Prevent • Promote • Protect

Crystal Park Site 103, CP-17-007

Please accept the following comments from El Paso County Public Health regarding the project referenced above:

SITE PLAN AND TOPOGRAPHIC SURVEY

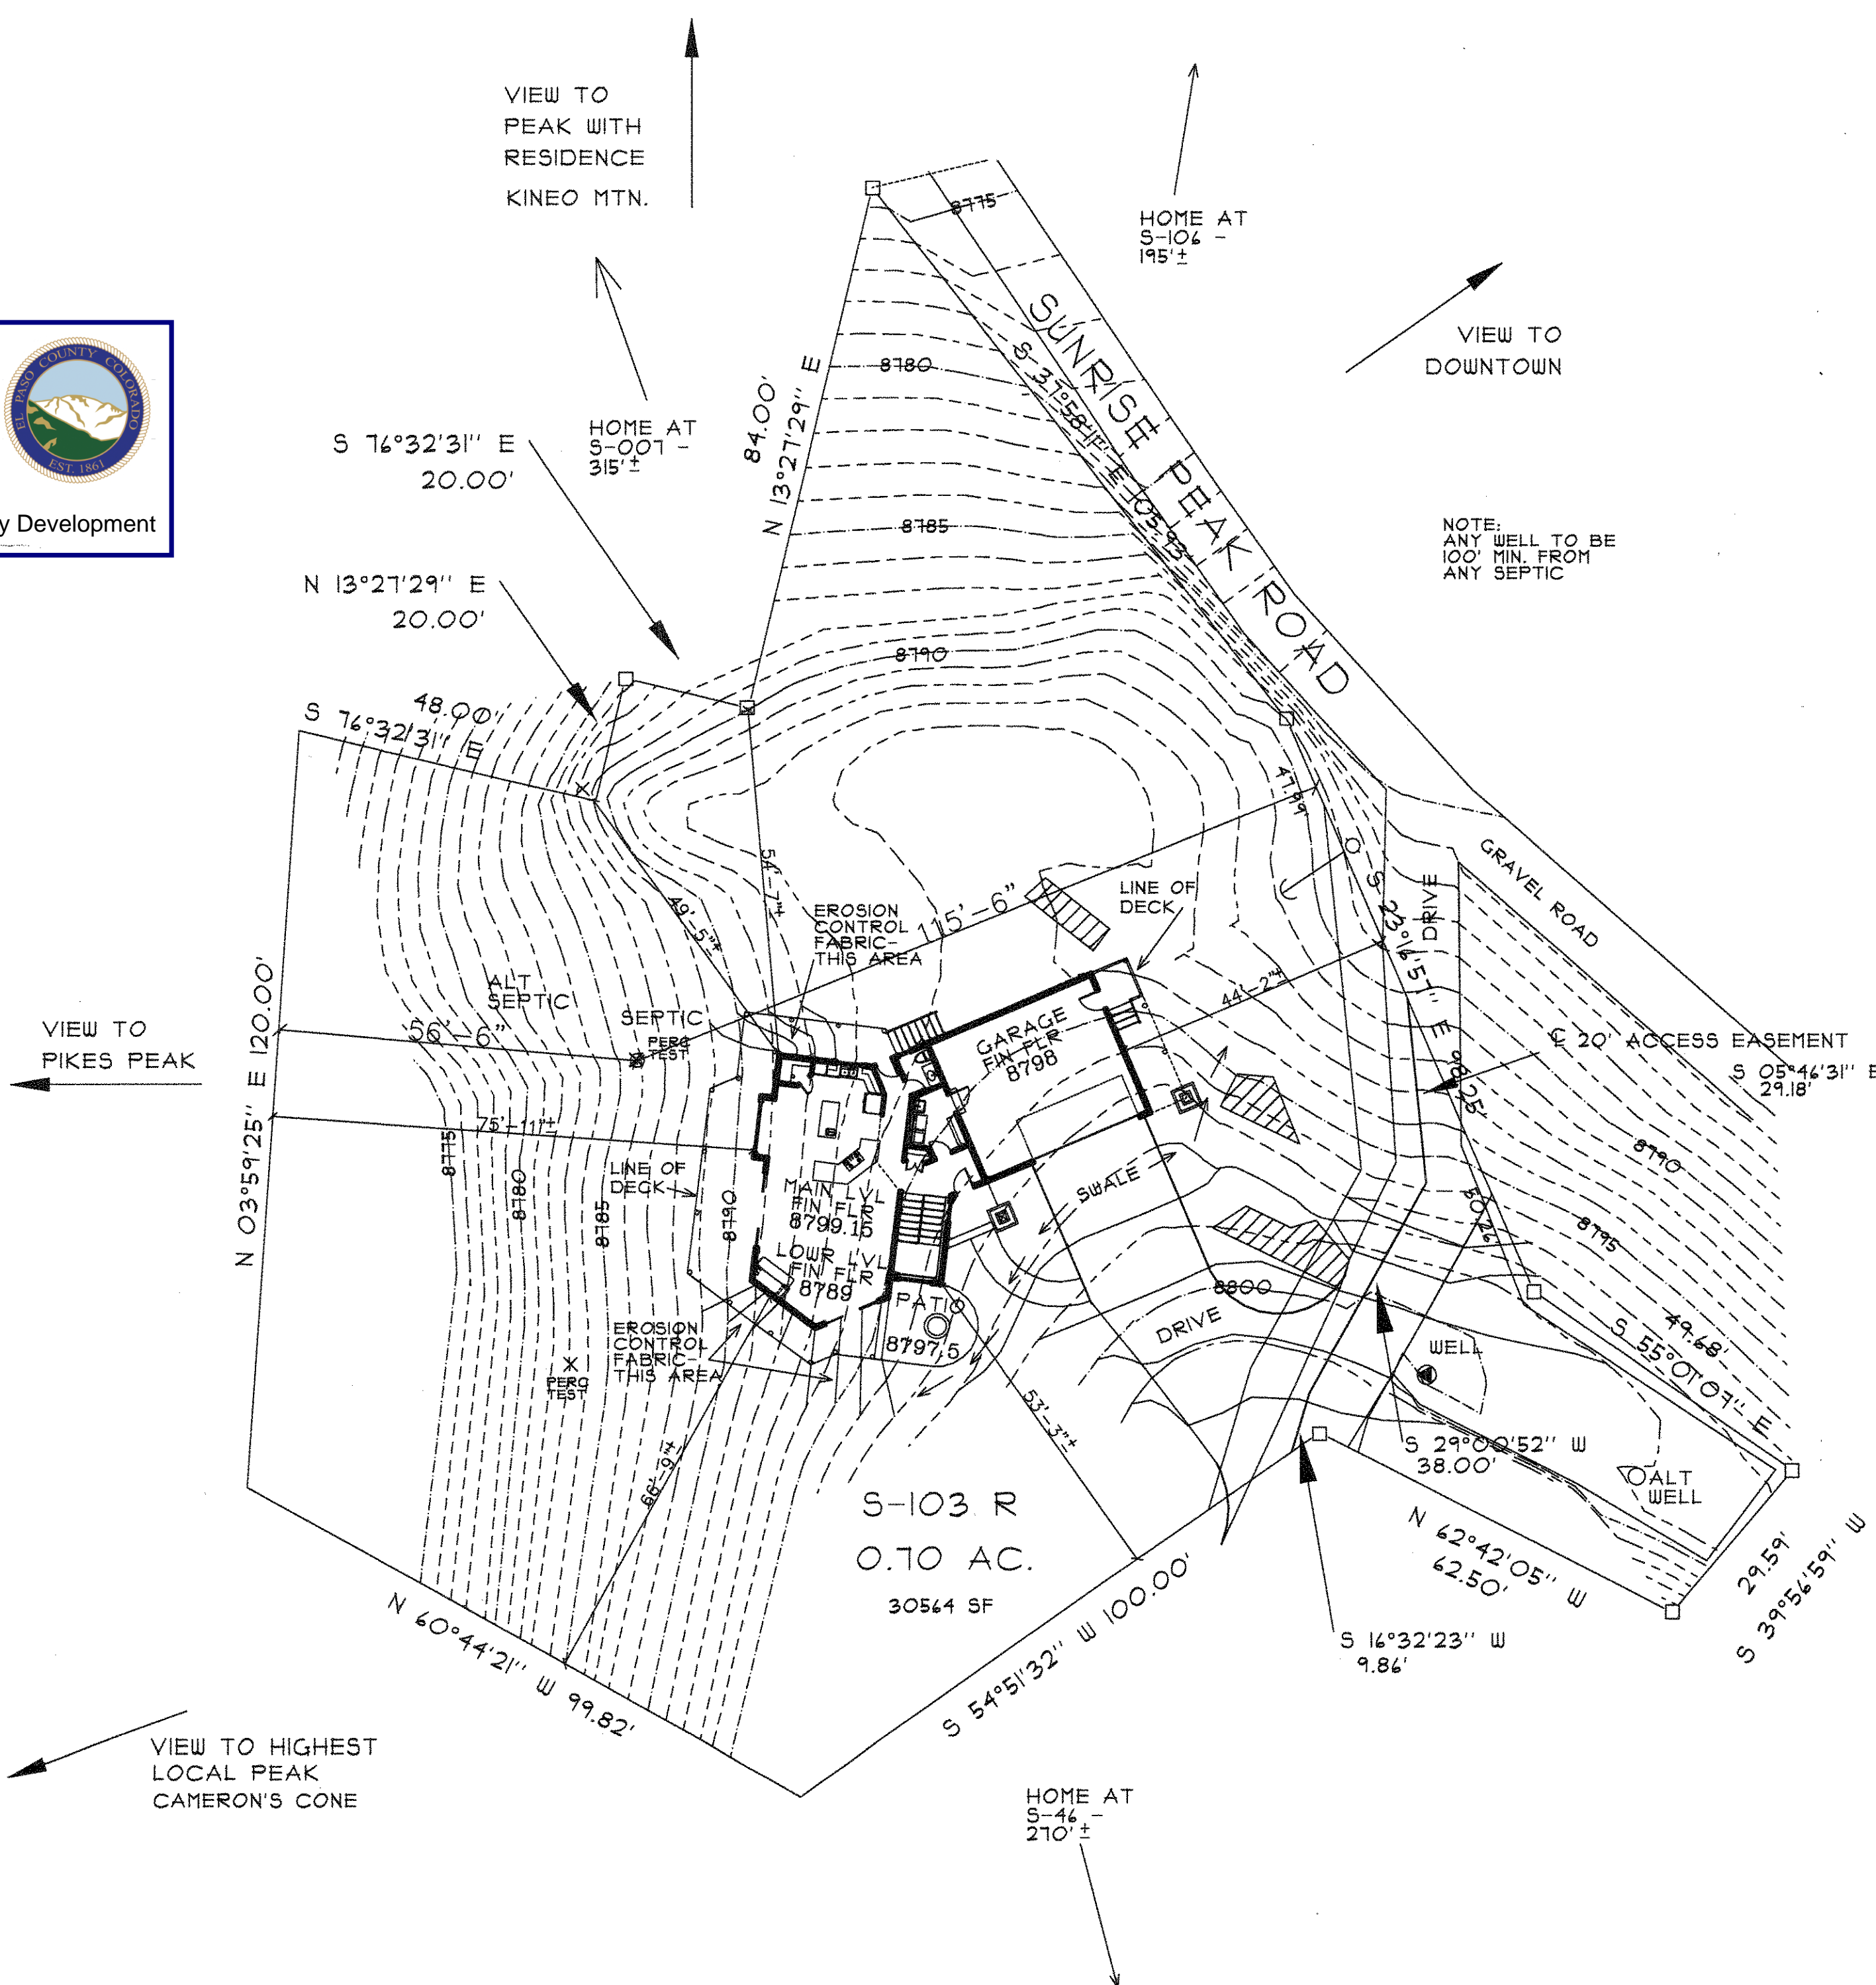
- **The site development plan indicates a “Perk Test” area and an area for an alternate septic site. The OWTS must meet all current El Paso County Public Health OWTS Regulations including OWTS permit approval. Please be aware that a vertical soil treatment area (STA) or “seepage pit or drywell” is the last type of STA to be considered for approval. The results of the soil test in these areas will determine the types of STA’s to be considered for approval.**

- **The OWTS STA’s must be 100’ minimum from any well, internal or external, and also must be protected from all house construction and site development activities. Compaction of the area by such activities may cause the area to be unsuitable for the STA installation. Adjacent property well locations were not shown on the Site Plan; therefore, be aware of the specific 100’ setback requirements as noted on the plan.**
